Crayfern Homes
Cinders Lane Nursery
Yapton
BN18 0JJ

Your Ref:
Our Ref: Y/68/20/NMA

Non-material amendment following grant of Y/4/19/RES for the addition of en-suite bathrooms to 6no. 2 bed houses (plots 10,28,29,49,50&51) including the addition of corresponding rooflights. Adjustment in horizontal position of rear facing bedroom windows to plots 10 & 49.

Cinders Lane Nursery And Works To The Rear Cinders Lane Yapton BN18 0JJ

PLOT 10-11&48-49 | PLANS & ELEVATIONS
DEVELOPMENT AT:
CINDERS LANE
YAPTON

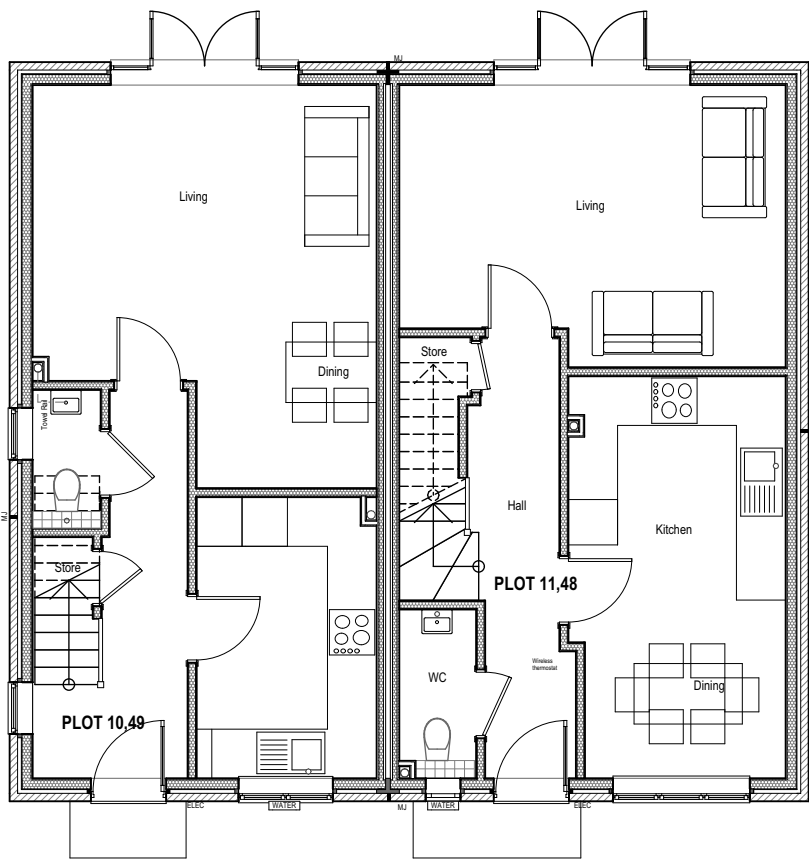
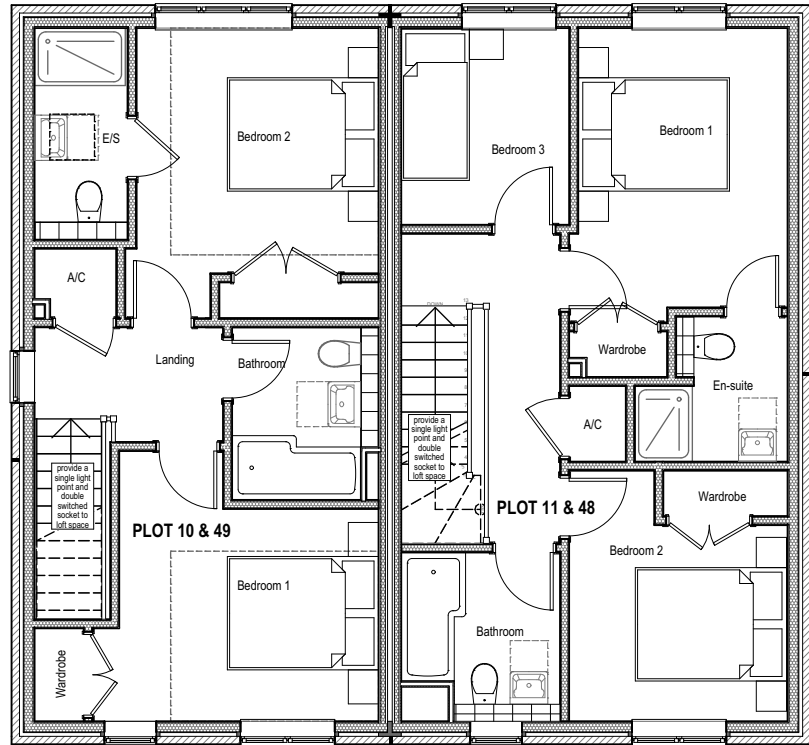
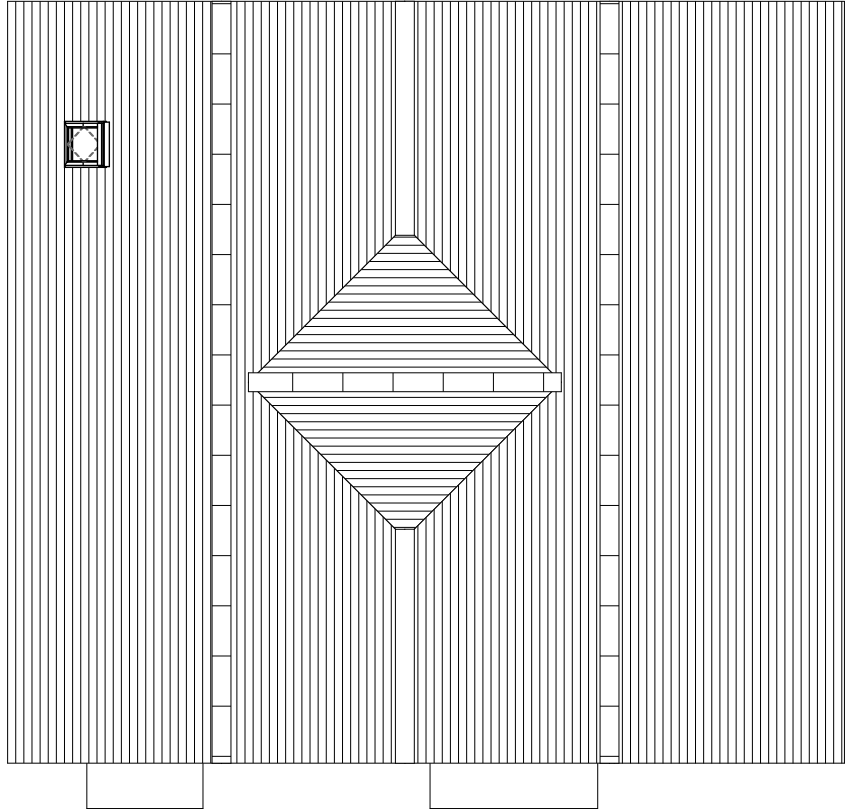
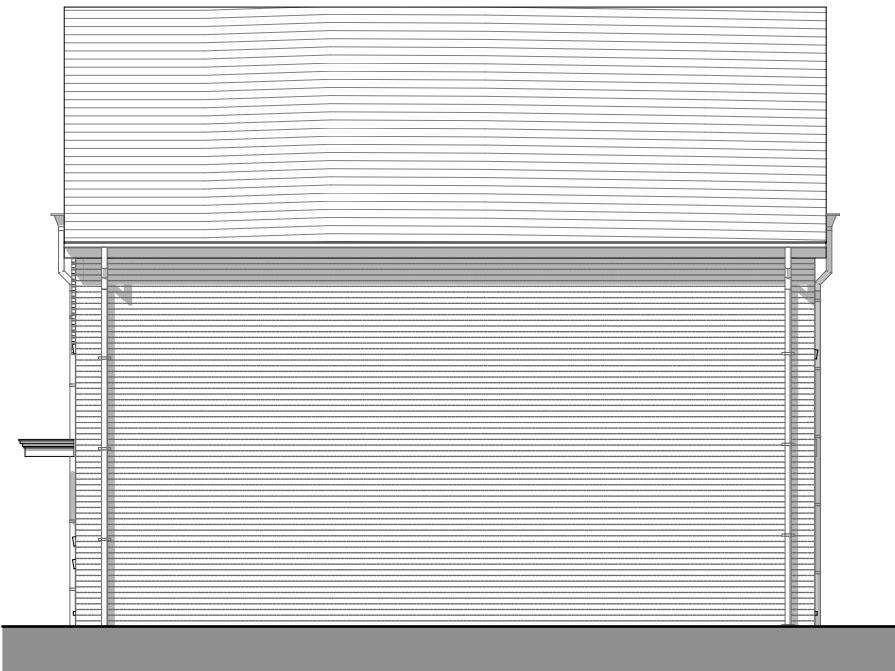
I refer to your recent application for a Non Material Minor Amendment. I note that you propose to add new en-suite bathrooms & corresponding rooflights to plots 10, 28, 29, 49, 50 & 51) and also adjust the horizontal position of the rear facing bedroom windows to plots 10 & 49.

Please note that the drawings "Proposed Floor Plans & Elevations Plots 10-11 and 48-49" Dwg No 19.14.P407_A; and "Proposed Floor Plans & Elevations Plots 28-29, 37-38 and 50-51" Dwg No 19.14.P414_A replace the corresponding drawings previously approved by Y/4/19/RES.
